Drehid Wind Farm Planning Application

Case reference number An Coimisiuin Pleanála 322845.Kildare Co.Co. being the Planning Authority a for wind Farm in the town lands of Coolea, Killeen, Kilmurray and Timahoe East Co.Kildare
The acceptance of this planning permission, from North Kildare Wind Farm Limited, using current Wind Energy Guidelines is ILLEGAL. The European Court of Justice has ruled, in decision C-24/19, that the Wind Energy Guidelines are plans and programs. As set out in Directive 2001/42/EU. The Irish Wind Energy Guidelines do not HAVE An SEA.(A Strategic Environmental Assessment) Recent decisions by the Irish Courts declare Wind Turbines of the Danish Concept Design generate nuisance by their actual method of operating. The Nuisance can only cease impacting people when they cease operating.

Name of Project: Drehid Wind Farm.

Reference Number of application: Coimisiuin 322845

PROJECT	CLIENT		
DREHID WIND FARM & SUBSTATION	NORTH KILDARE WIND FARM Ltd.		
SHEET	Date 11.03.25	Project number P22-242	Scale (@ A1-) As Shown
T1 TURBINE ELEVATION & HARDSTAND DETAIL	Drawn by CS	Drawing Number P22-242-0300-0012	Rev A
	Checked by BC

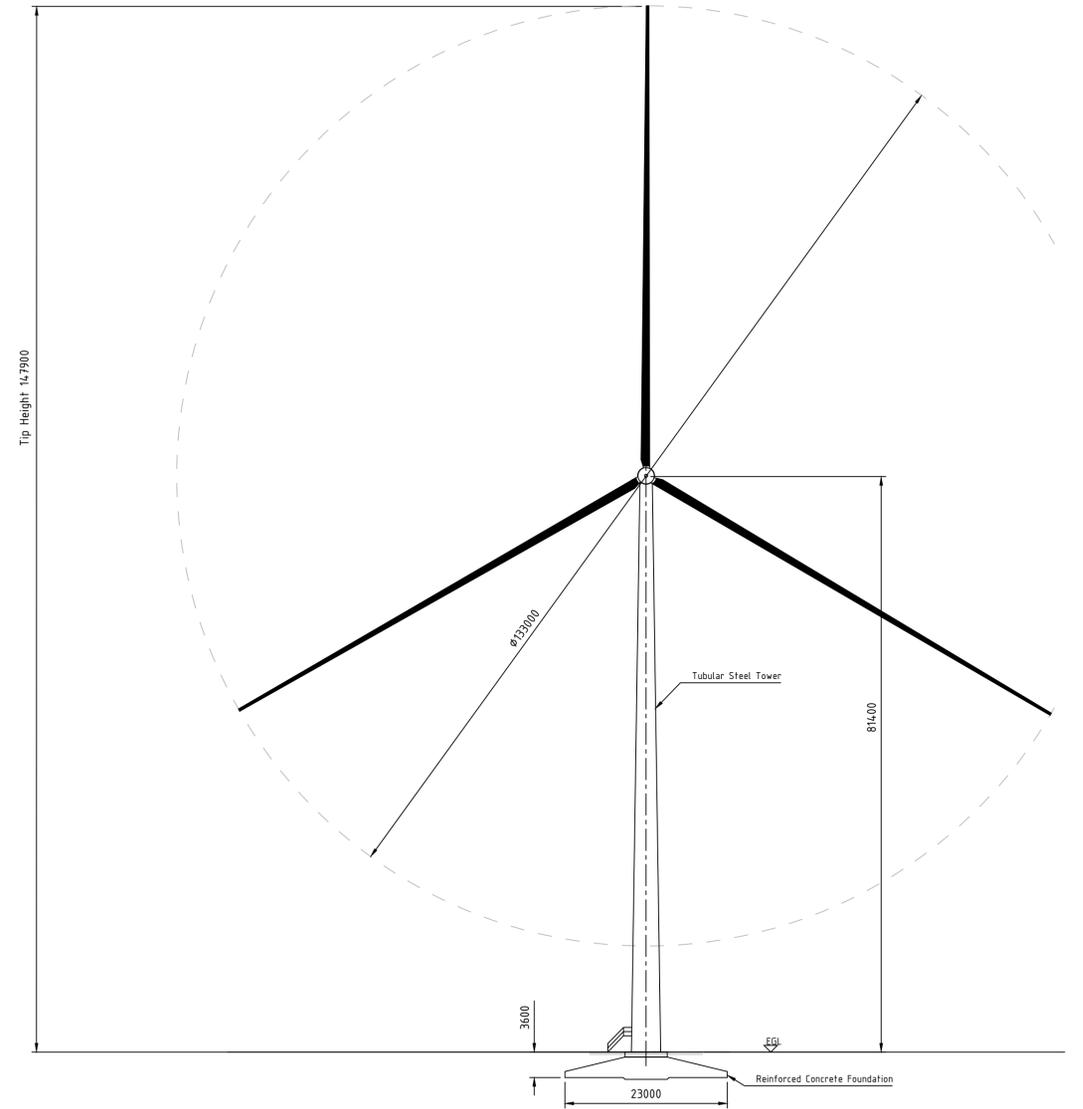
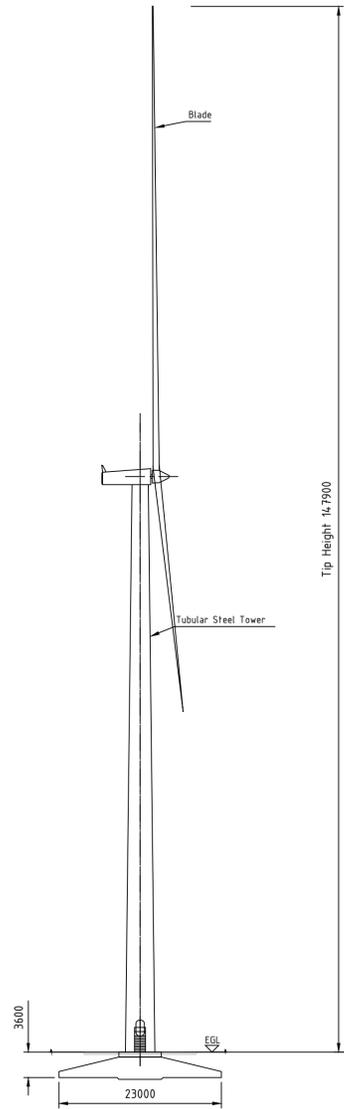
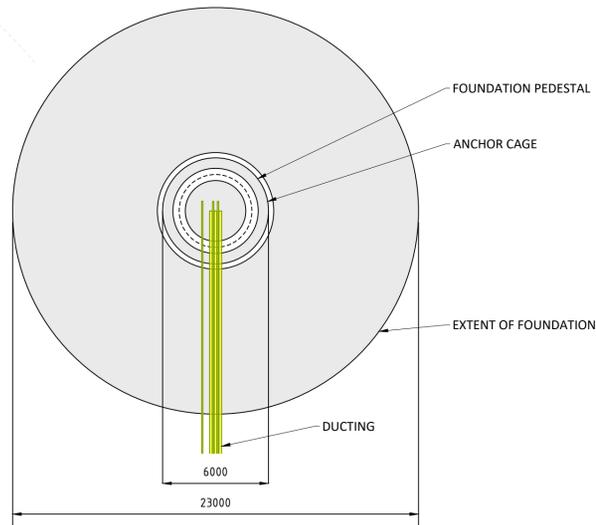
Wind Turbine Configuration/Arrangement from the Drawings likely to be of considerable noise nuisance.

Configuration/Layout of T1& T2 will likely cause more than significant noise nuisance as per Gibbet Hill noise nuisance legal case, being less than or equal to 1050 meters from a inhabited location(s)
